STRUCTURAL PERMIT CORRECTIONS

May 5, 2022

RE Permit corrections for Koneru Residence at 6610 E Mercer Way, Mercer Island, WA 98040, Permit No. 2112-250

We have received and reviewed the STRUCTURAL comments regarding the 6610 E Mercer Way project, permit number 2112-250. Below are the corresponding responses to the structural comments for the correction notice prepared by Crystal Kolke, Kolke Consulting Group, Inc dated April 12, 2022:

**A16**

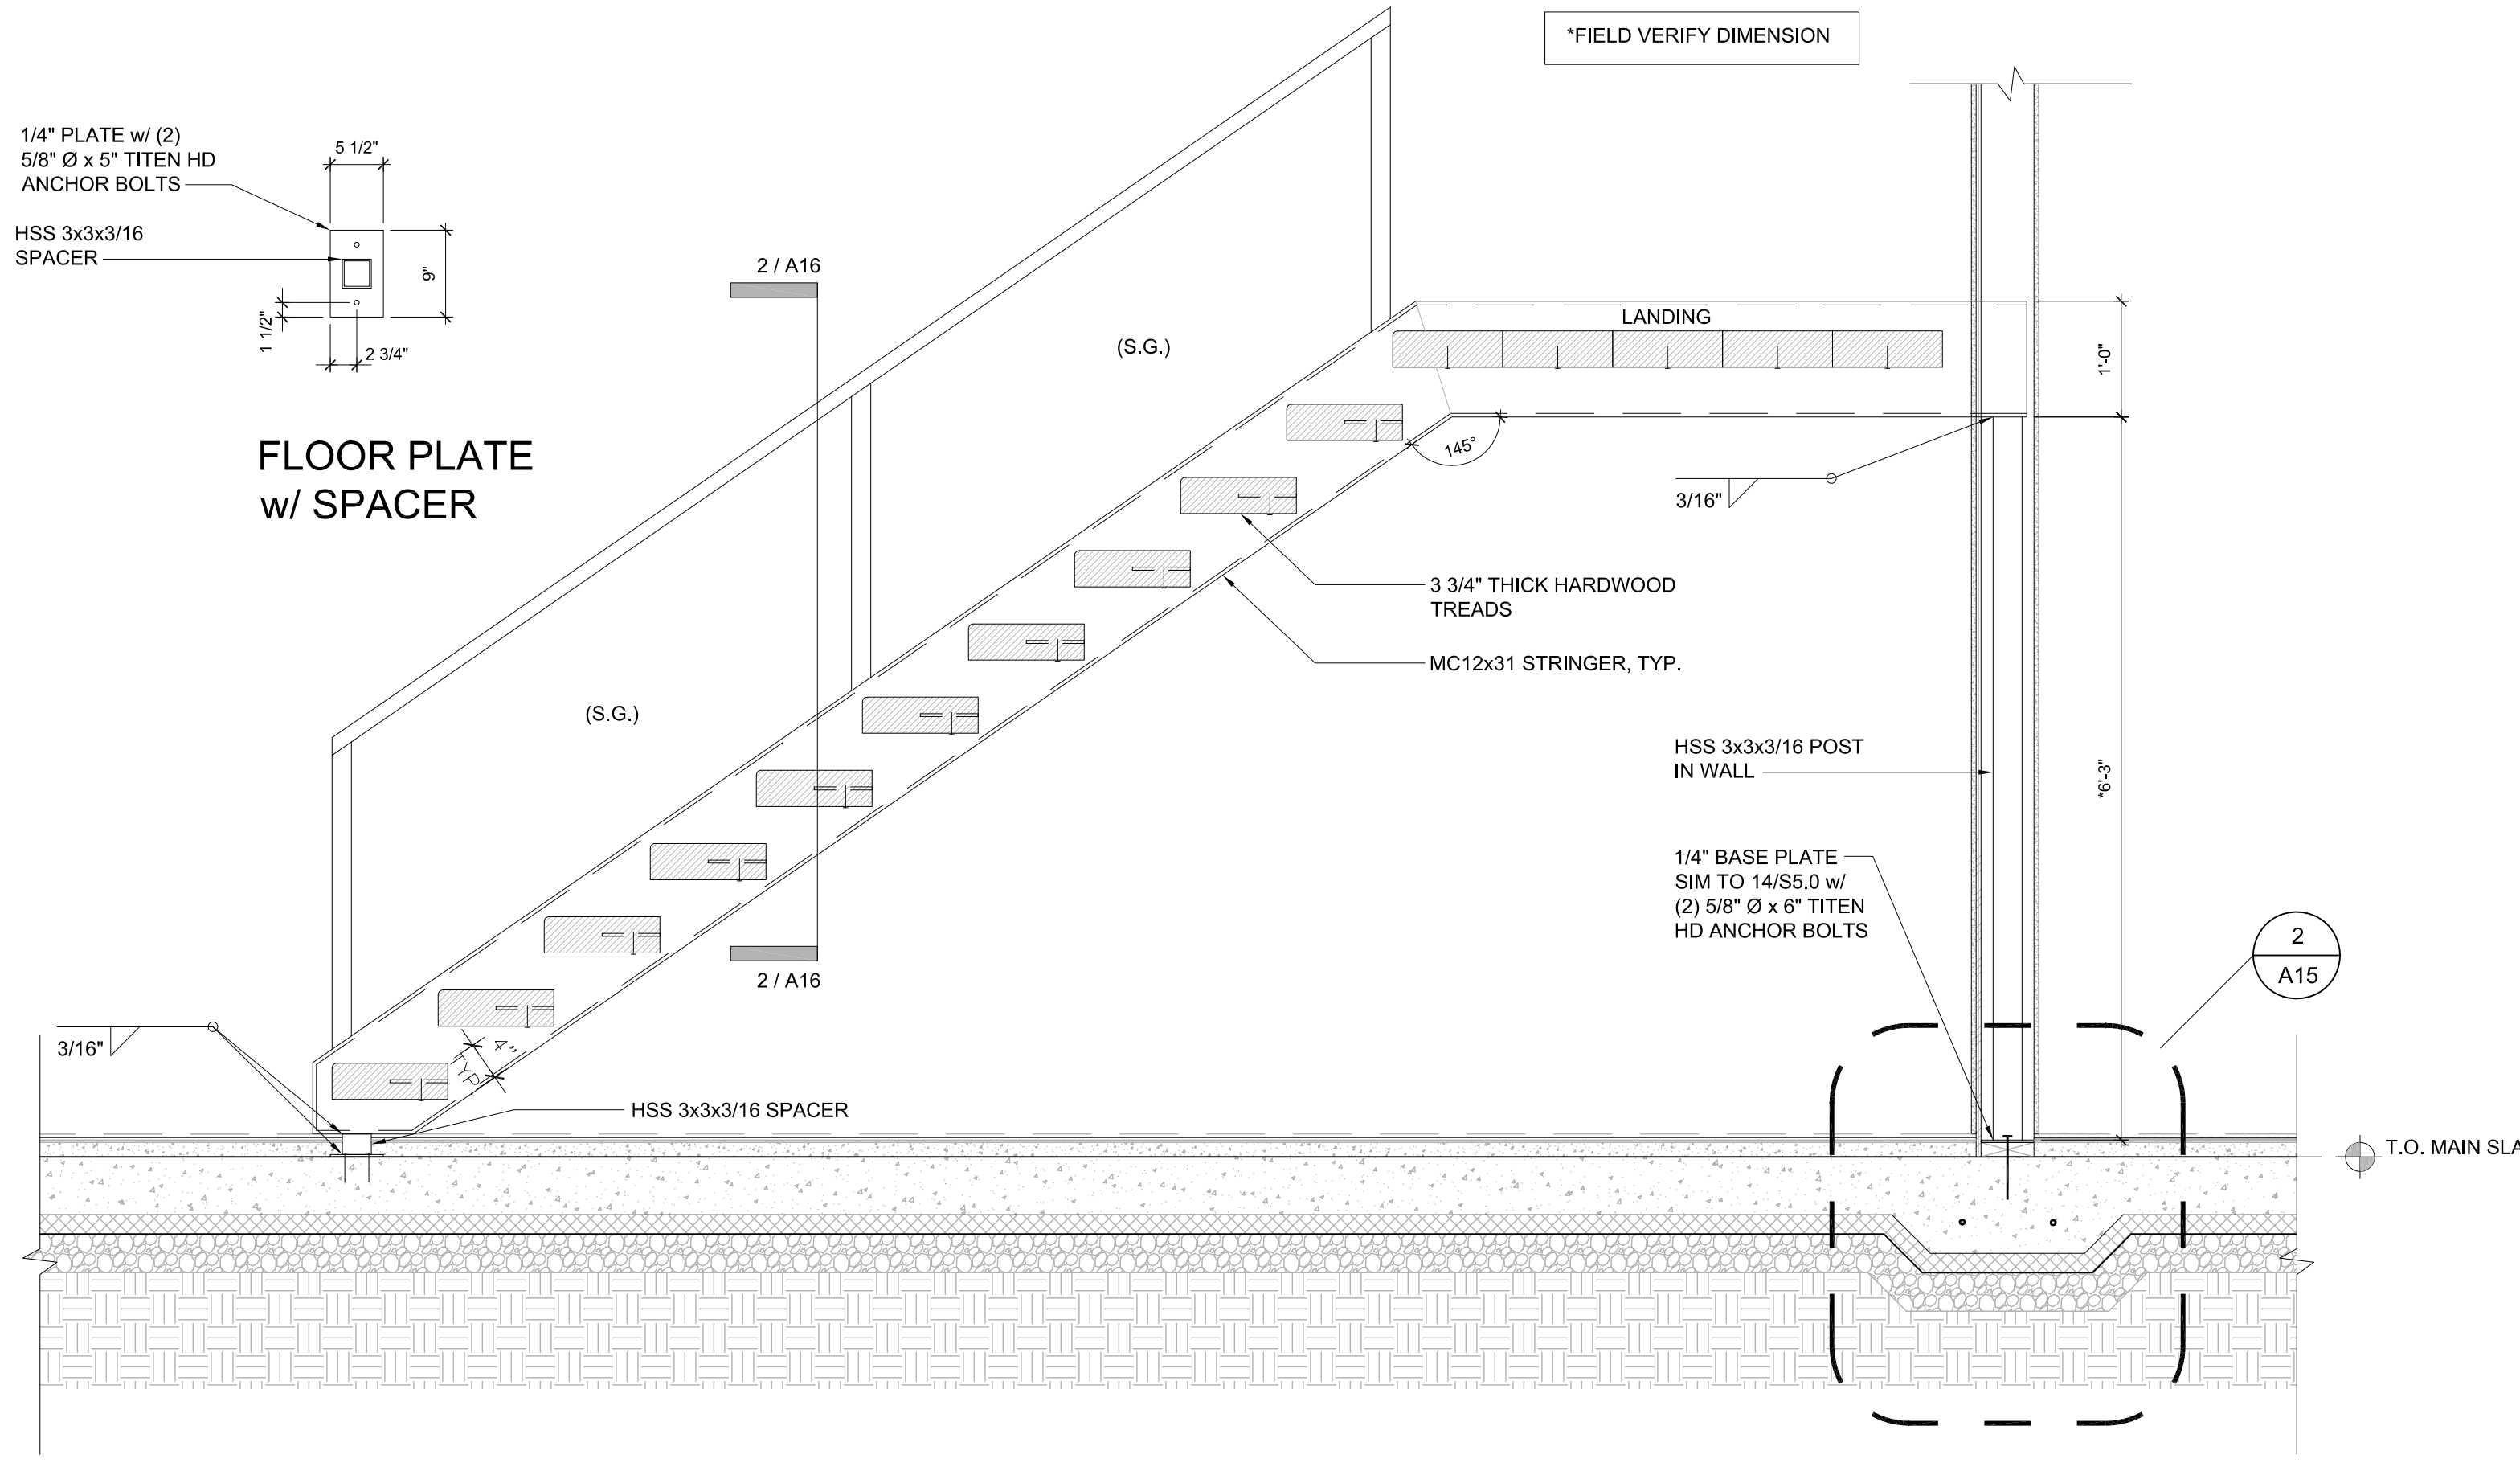
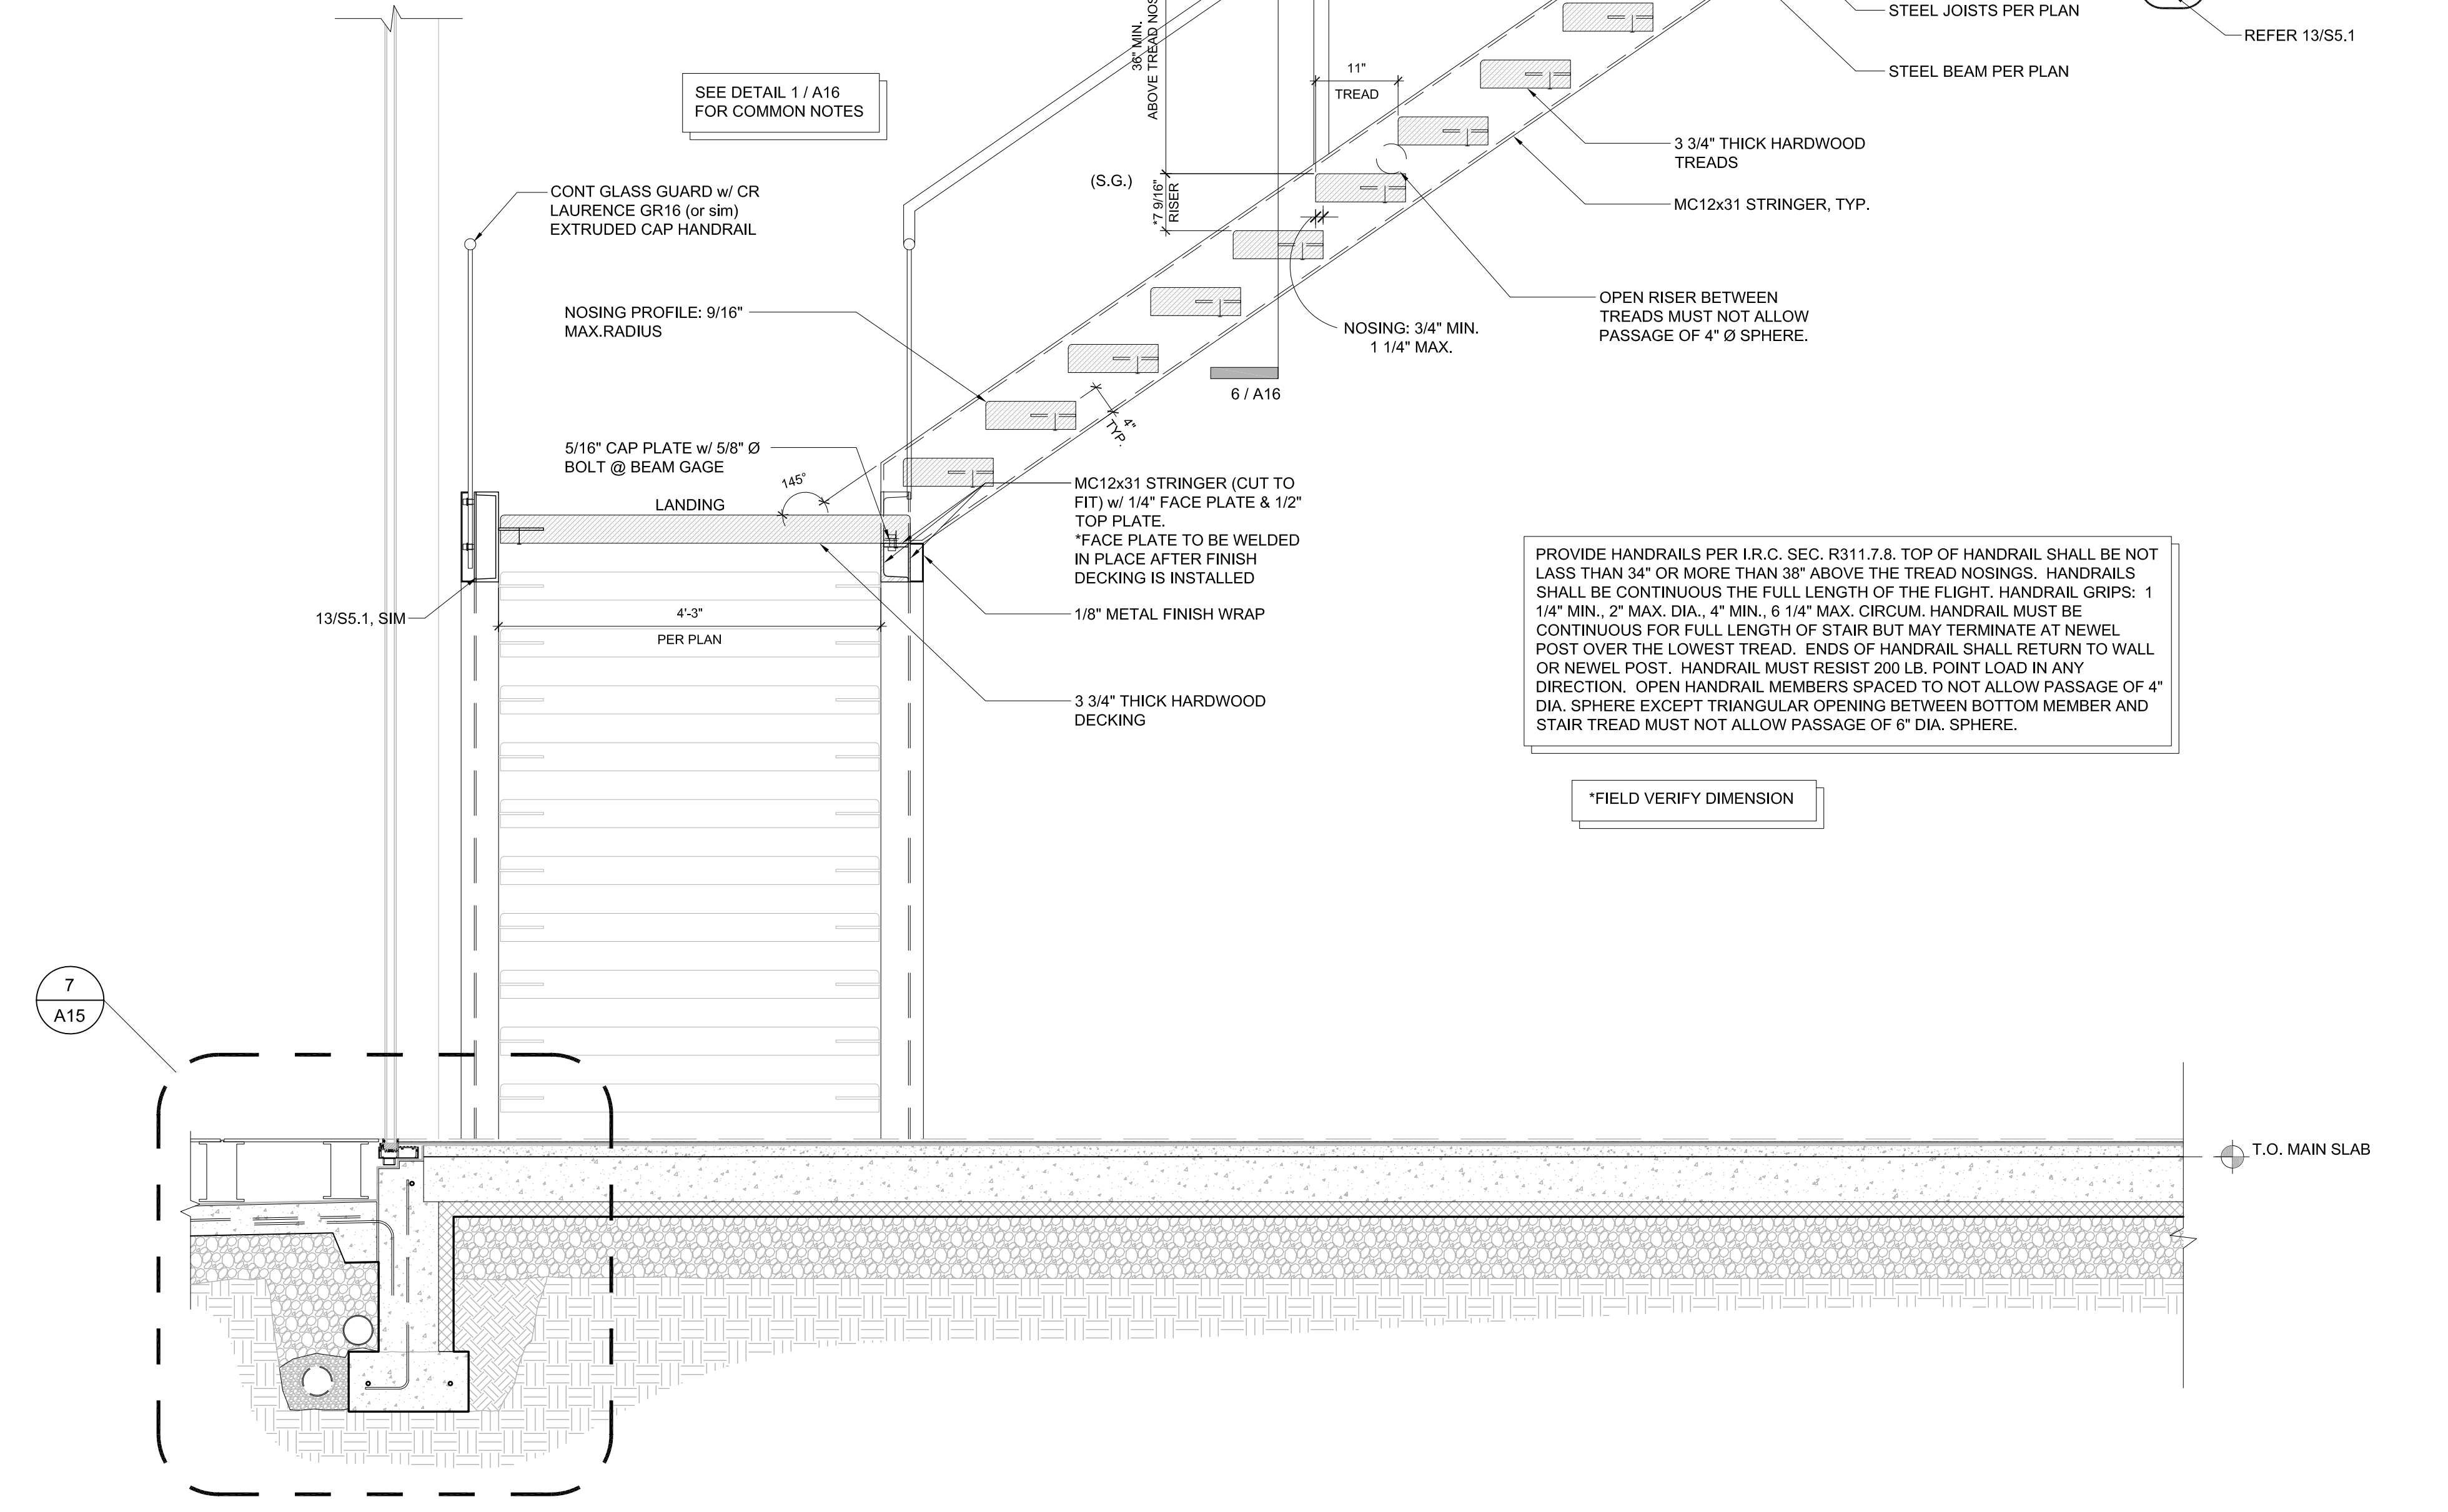
11. Stair and bridge connection details are shown on sheet A16. Bridge joists to beam welding connection has now been called out on plan sheet A6, and also typical bridge guardrail post required connection has now been called out on 13/S5.1.
